9. **Project# 1004468**
12DRB-70381 SKETCH PLAT REVIEW
AND COMMENT

**CITY OF ALBUQUERQUE
PLANNING DEPARTMENT
December 19, 2012
DRB Comments**

PROJECT # 1004468

RE: Lot 77-A, Block 7, Perfecto Armijo & Brothers Addn.

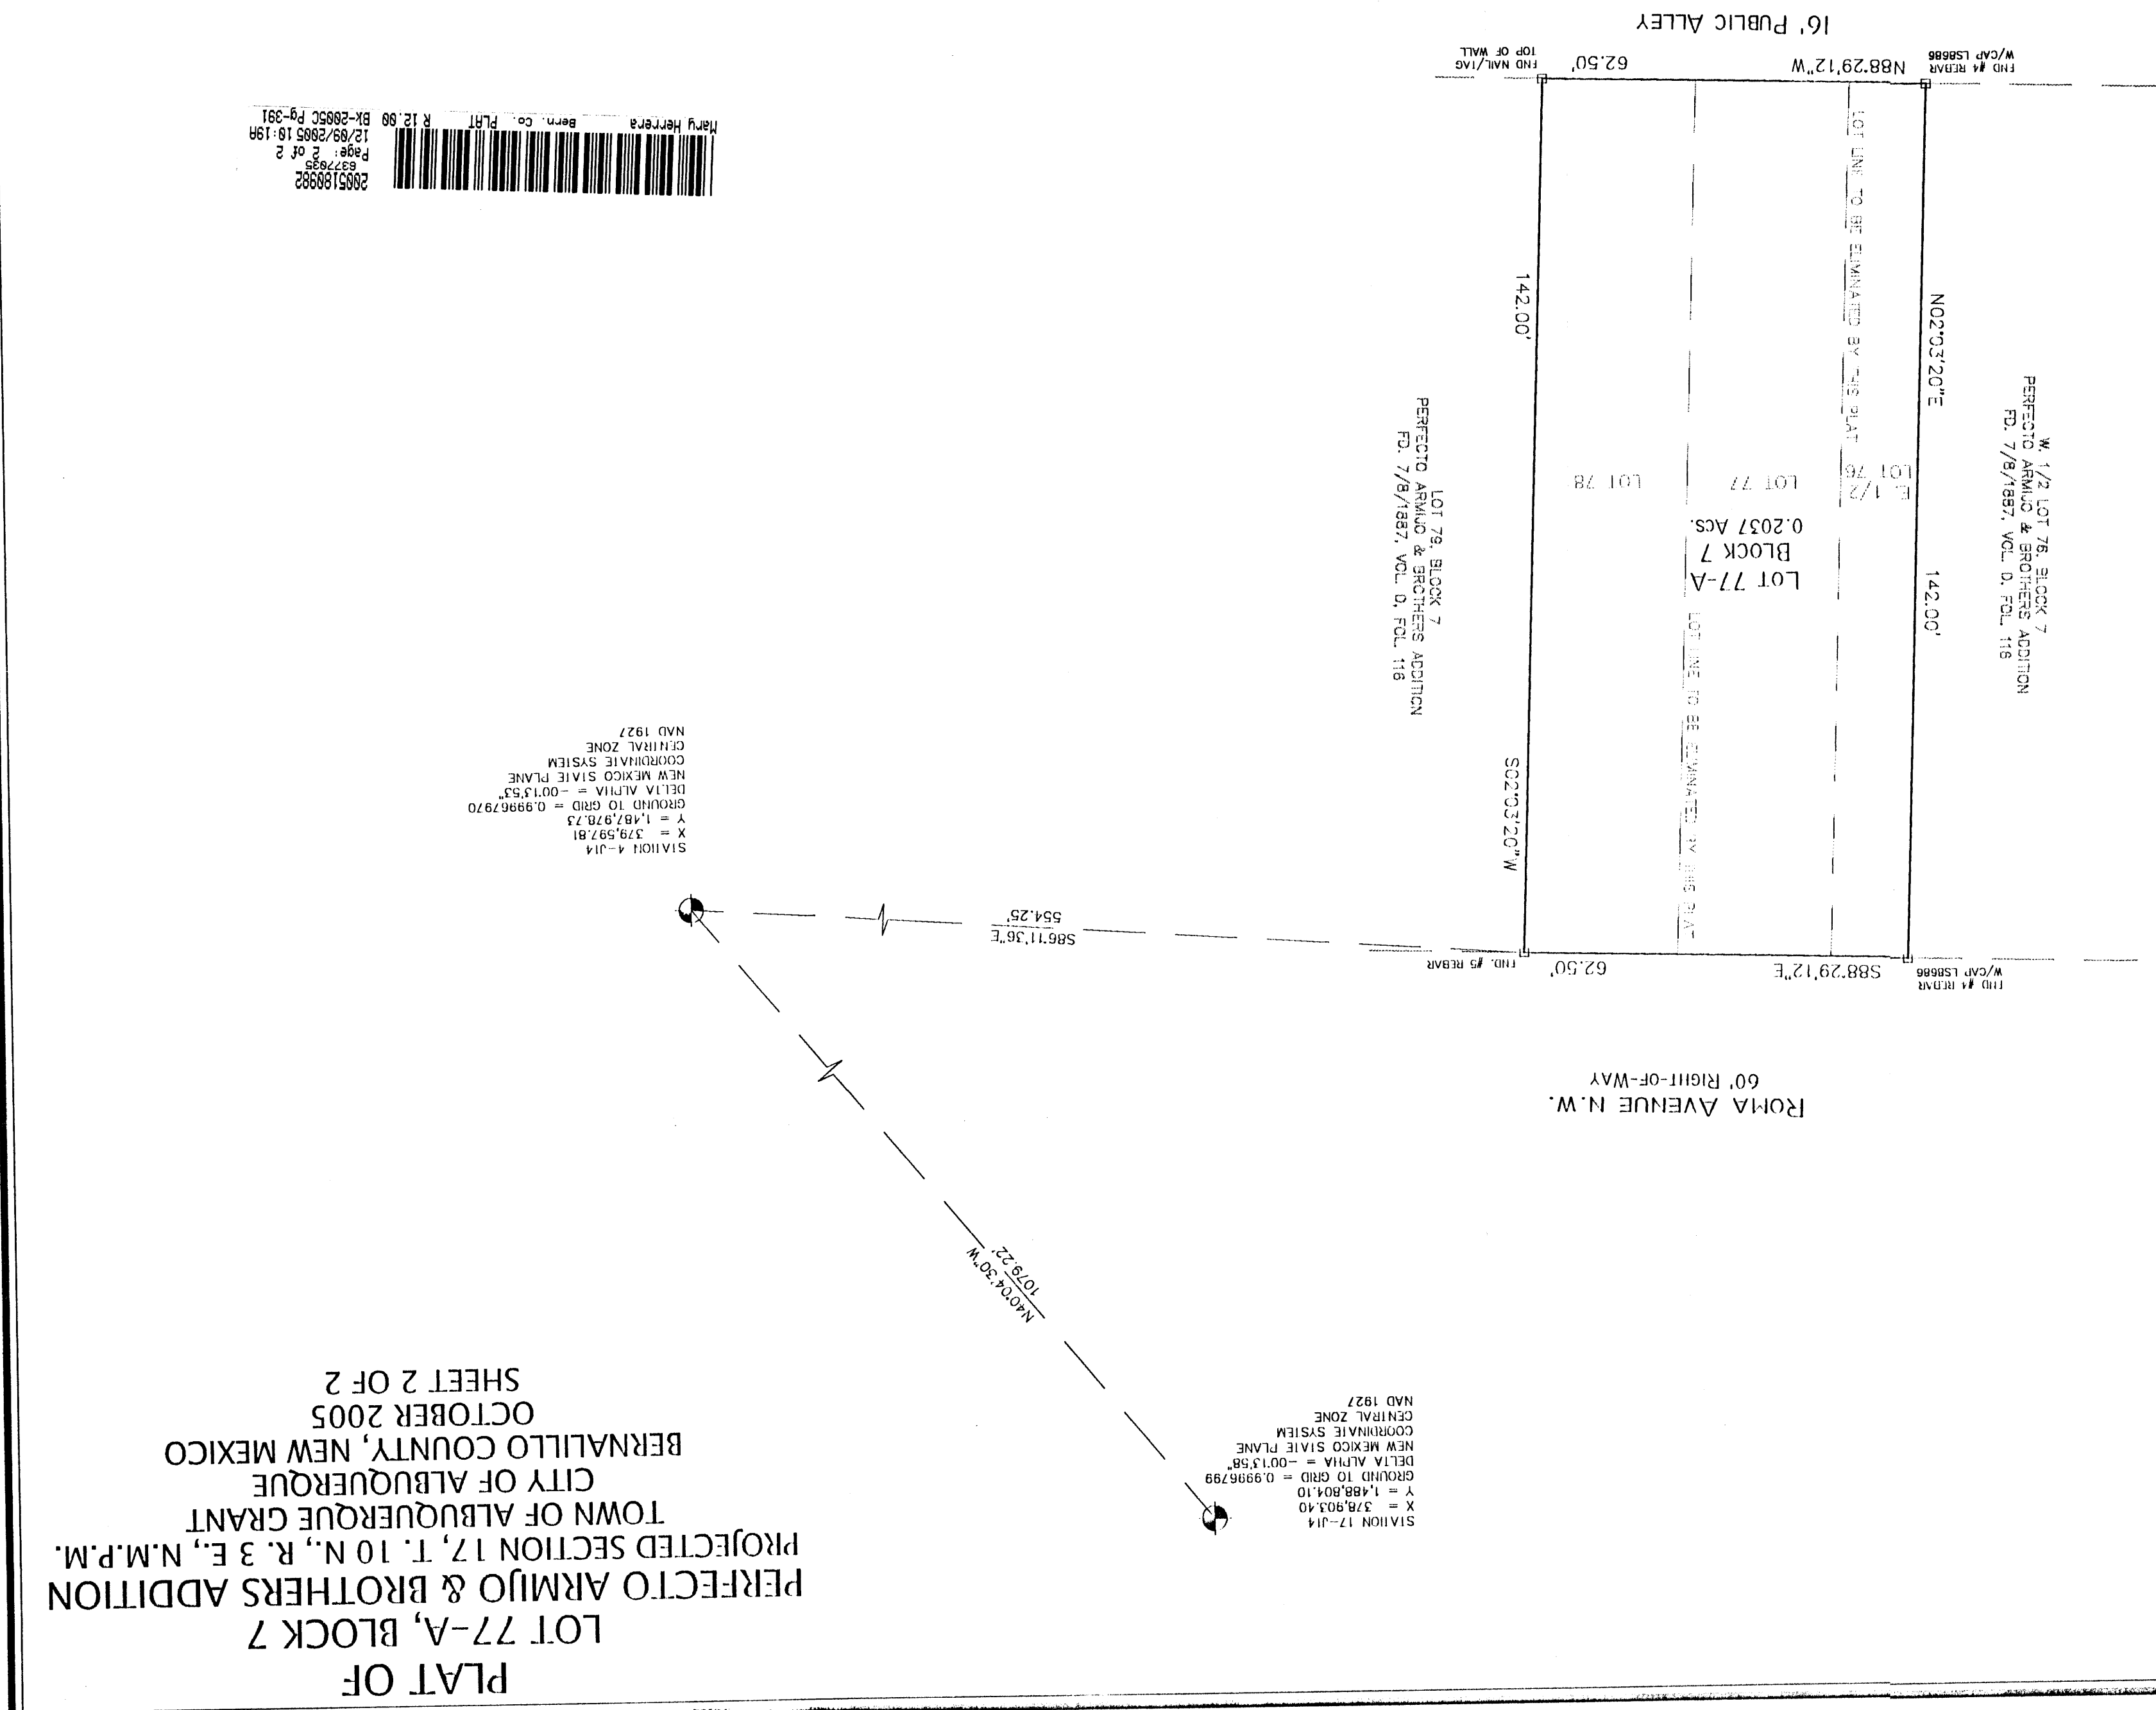
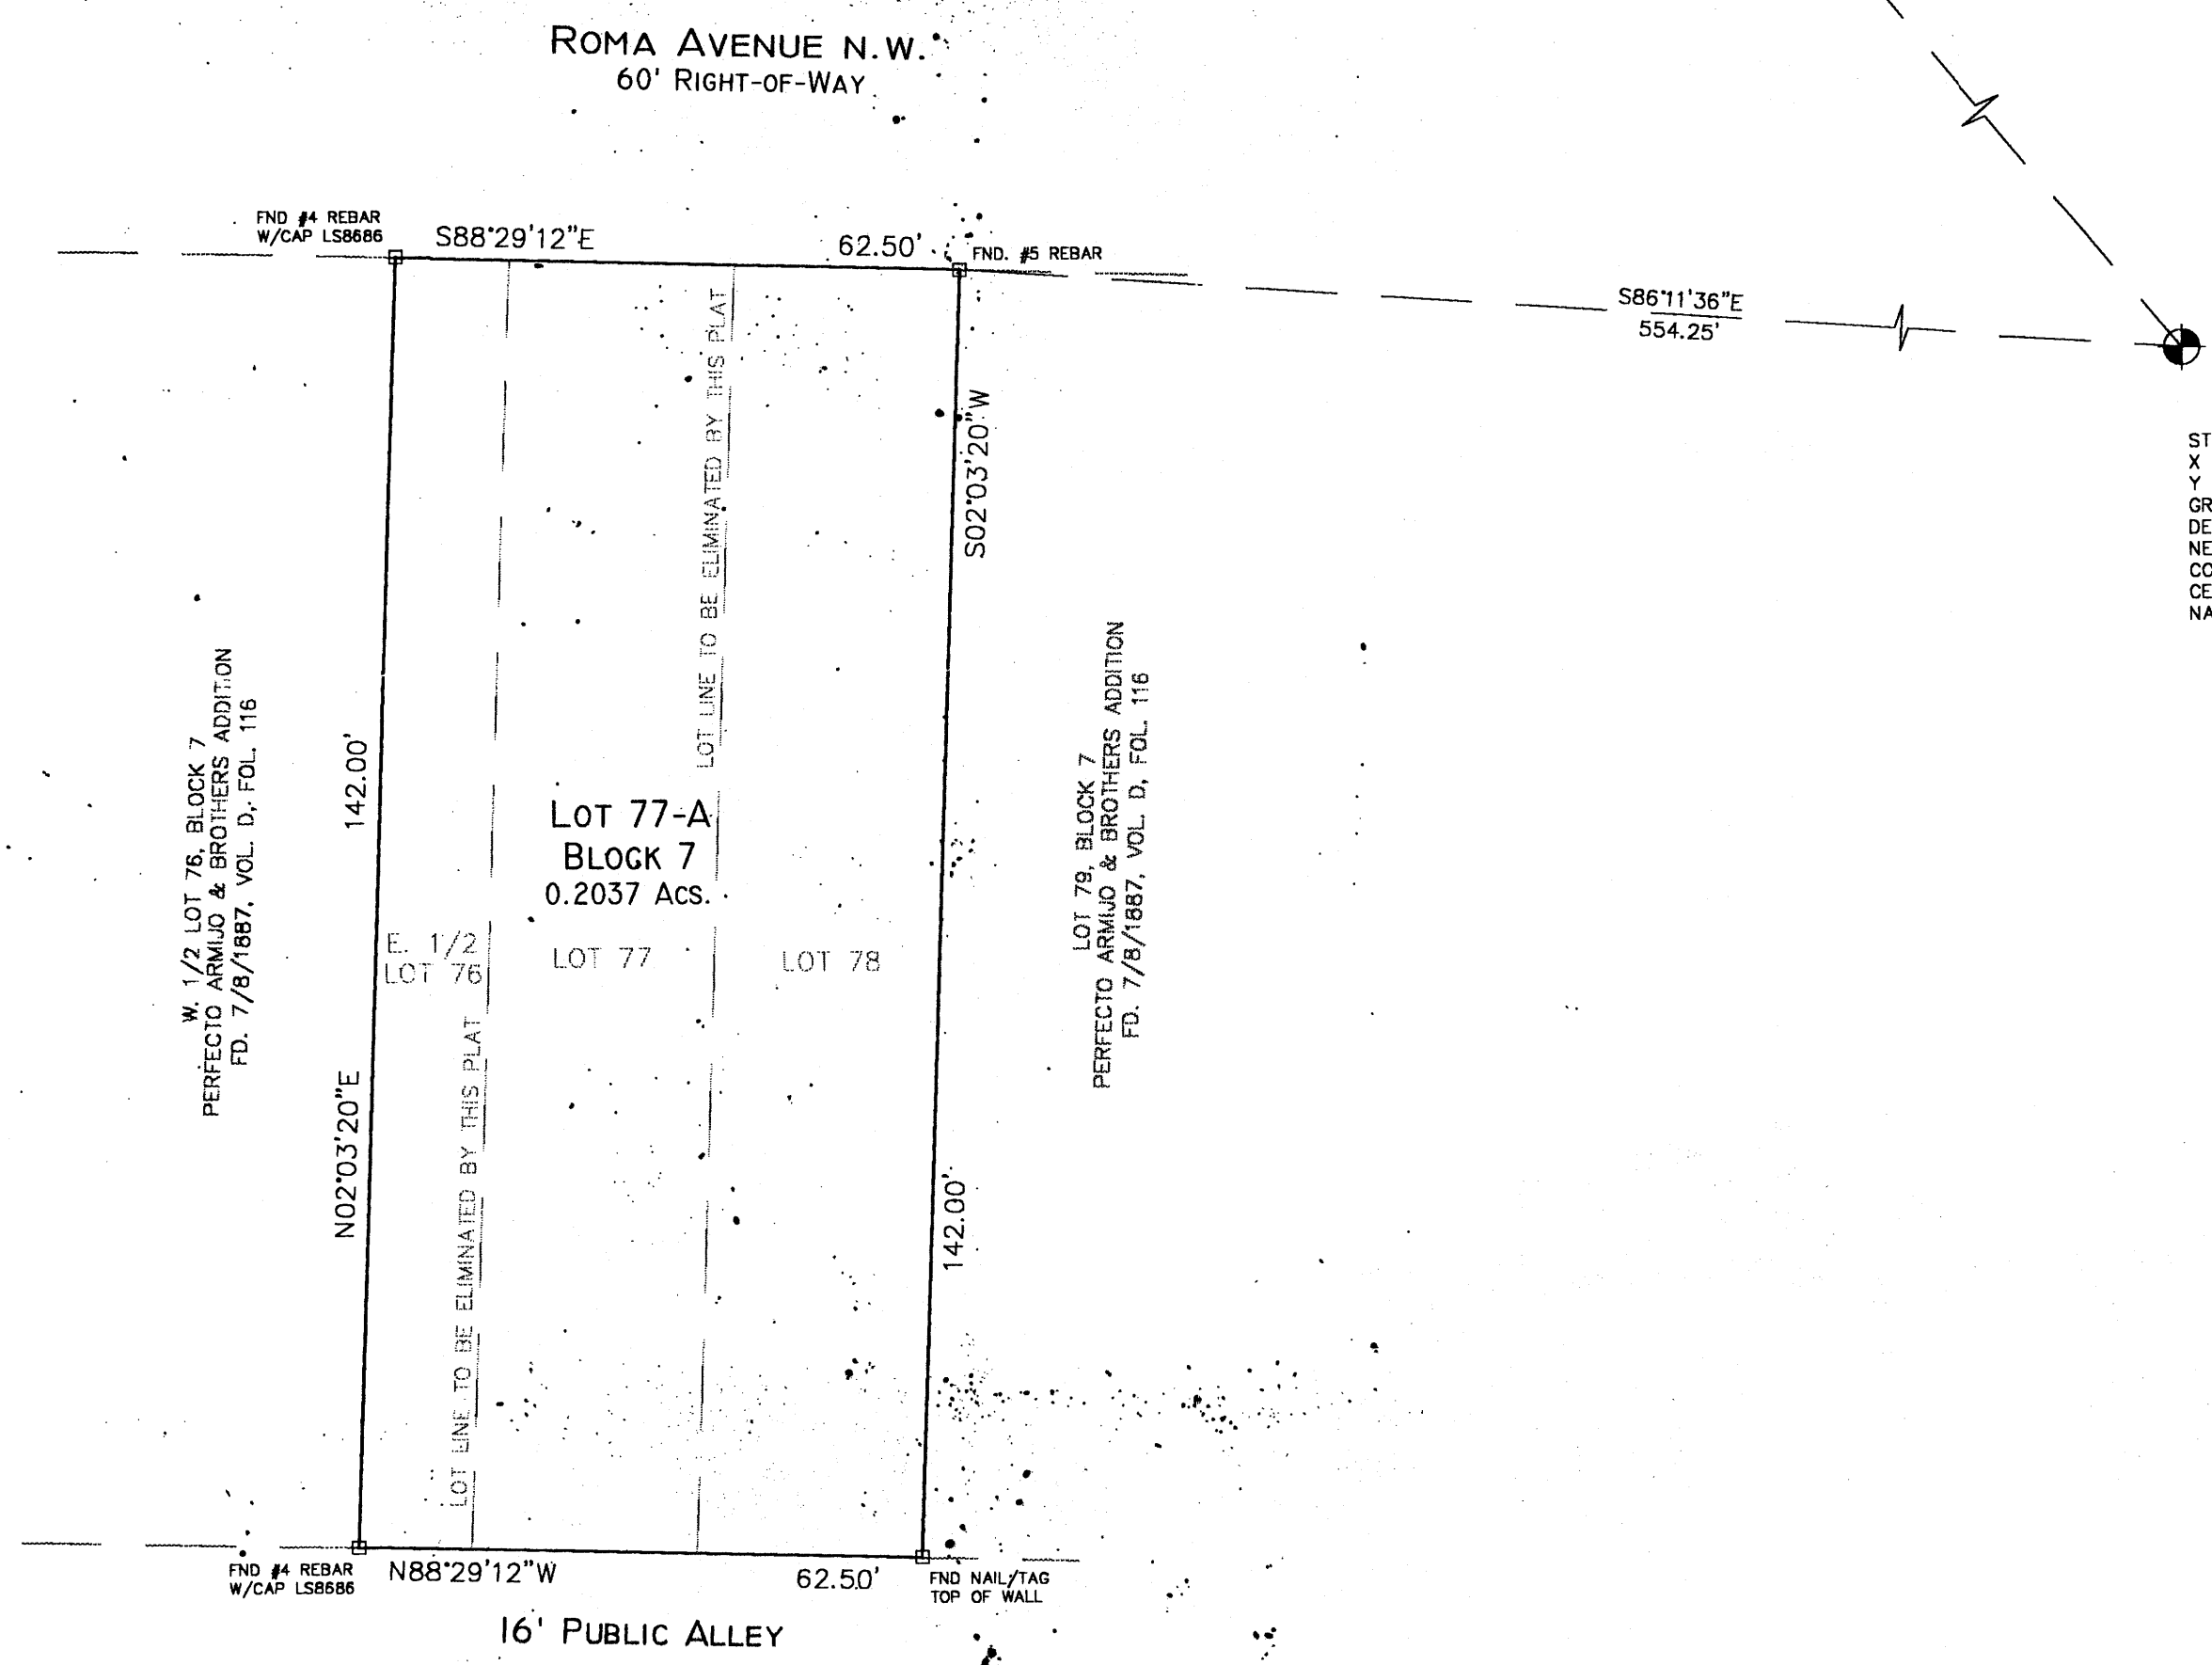
The site is zoned SU-2/ DNA-MR; per the Downtown Neighborhood Area Sector Development Plan, townhouses shall be regulated per the SU-2/ DNA-TH zone with exceptions.

While no lot lines have been presented with this Sketch Plat, it does not appear that the existing development can meet any townhouse platting requirements of the zoning code or sector plan. A zone change and sector plan amendment to Special Use/ SU-1 zoning plus site development plan for subdivision and site development plan for building permit would be required. If approved, extensive easements would be required and compliance with building code would have to be demonstrated, particularly for common walls on lot lines and individual water and sewer lines and accounts.
